Our Ref: 24/00613/HFUL
Your Ref: 1320 Church Lane, Milton

**South Cambridgeshire District Council
Application for Planning Permission**

Proposal: Single storey rear extension, conversion of existing garage and room above,
installation of solar PV panels to rear roof and removal of 2 No sycamore trees

Site address: 26 Church Lane Milton Cambridgeshire CB24 6AB

TITLE
Roof Plan -
Existing and Proposed

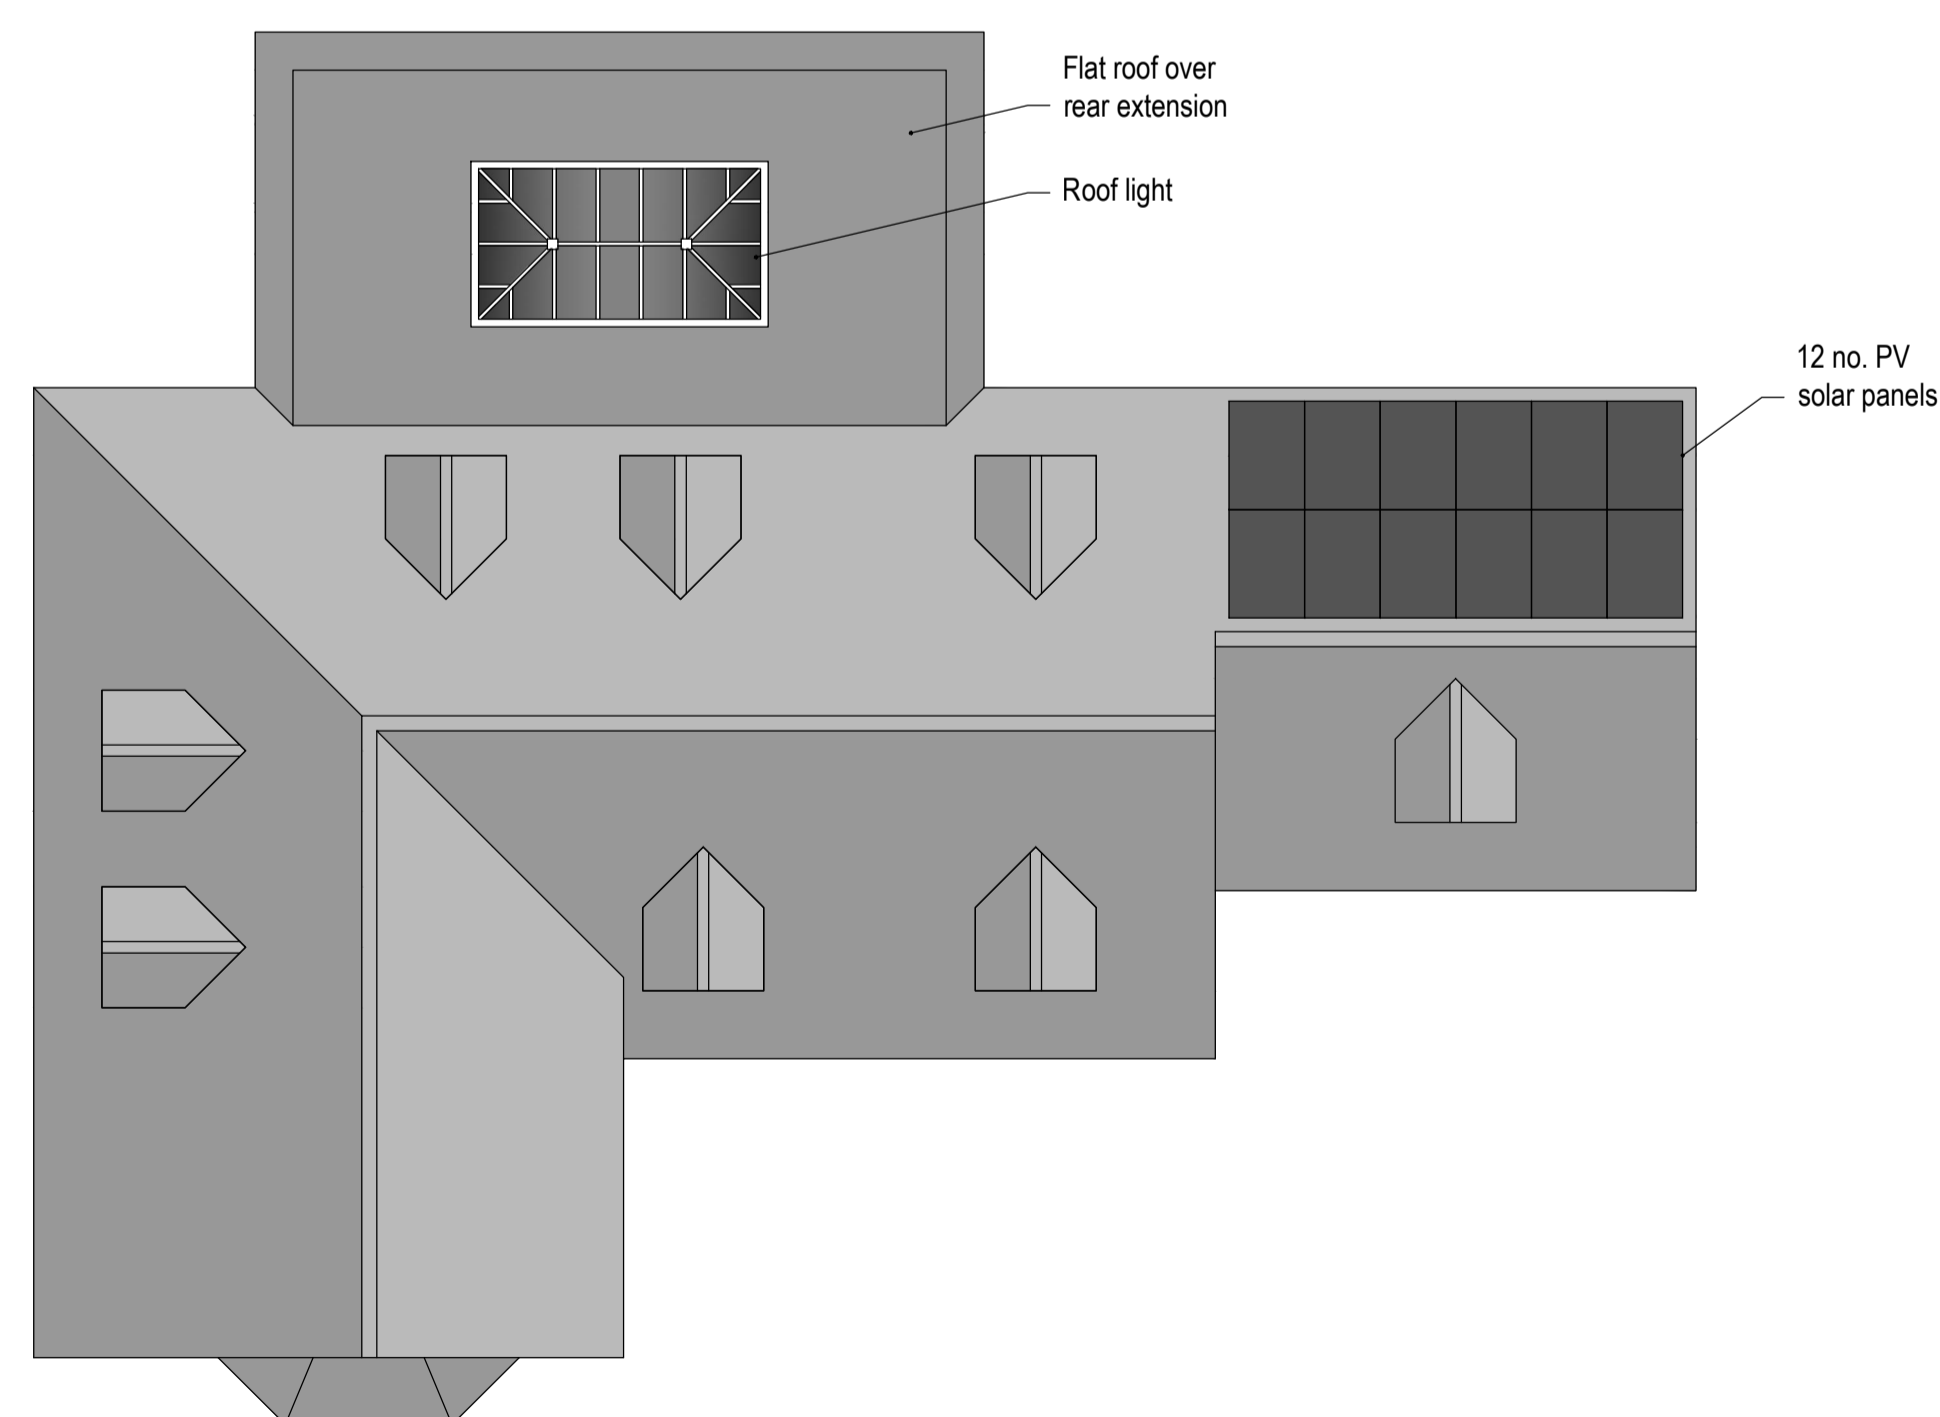
1. Please provide a roof plan which should also show the proposed PV panels on the rear roof.
2. Please confirm in writing whether you agree with the above amended description.
3. Please provide Manufacturers details and specifications of the proposed PV panels.
